April 11, 2014

RE: **O’Niell’s Addition & Remodel, 4310 Central Ave SE**  
**Grading and Drainage Plan**  
**Engineer’s Stamp Date 3-27-2014 (K17D100)**

Based upon the information provided in your submittal received 3-27-14, the above referenced plan is approved for Building Permit and SO-19 Permit based on the following condition:

### GRADING AND DRAINAGE PLAN

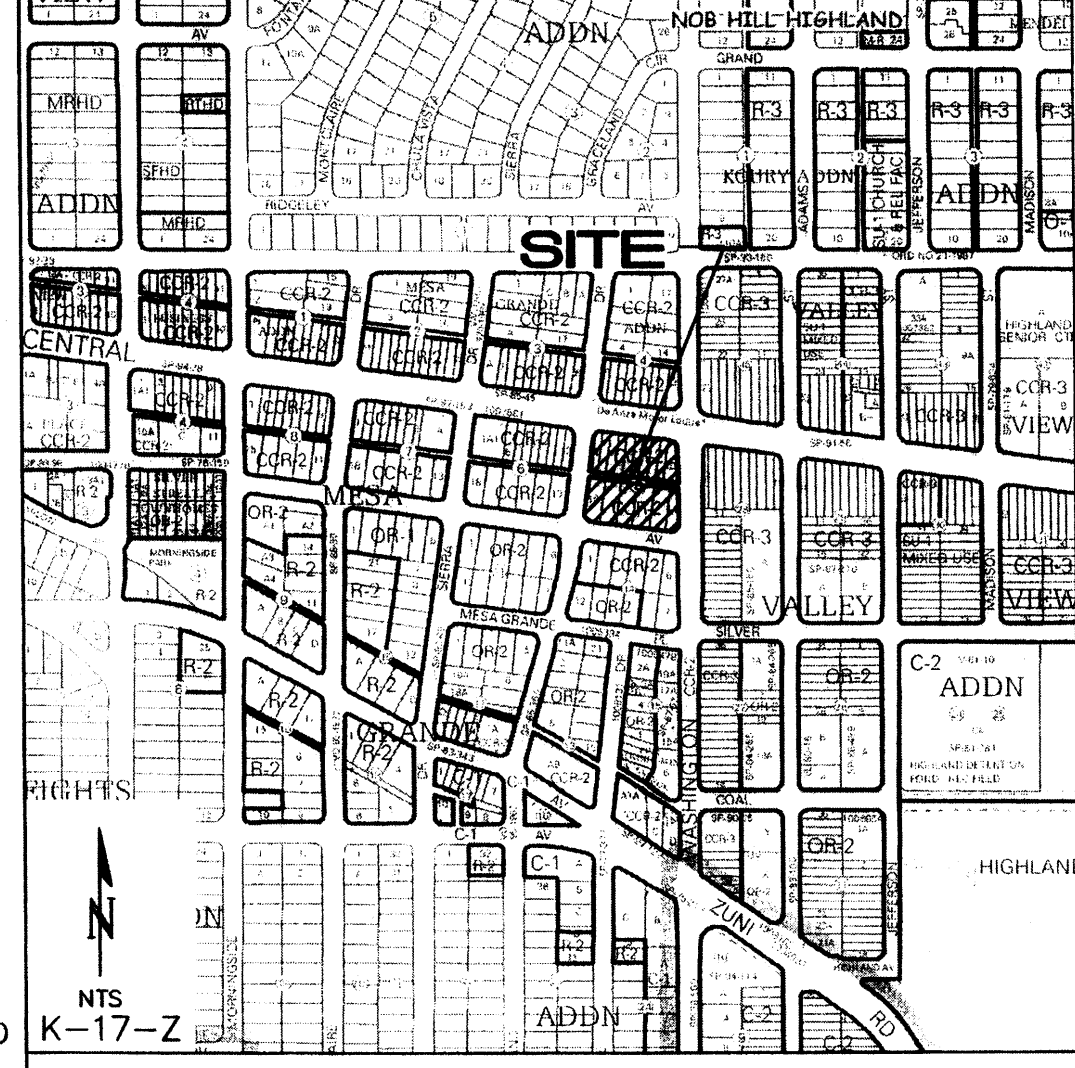
- Plat indicates there is a cross-lot drainage easement through replatted Lot 4A prior to Certificate of Occupancy.
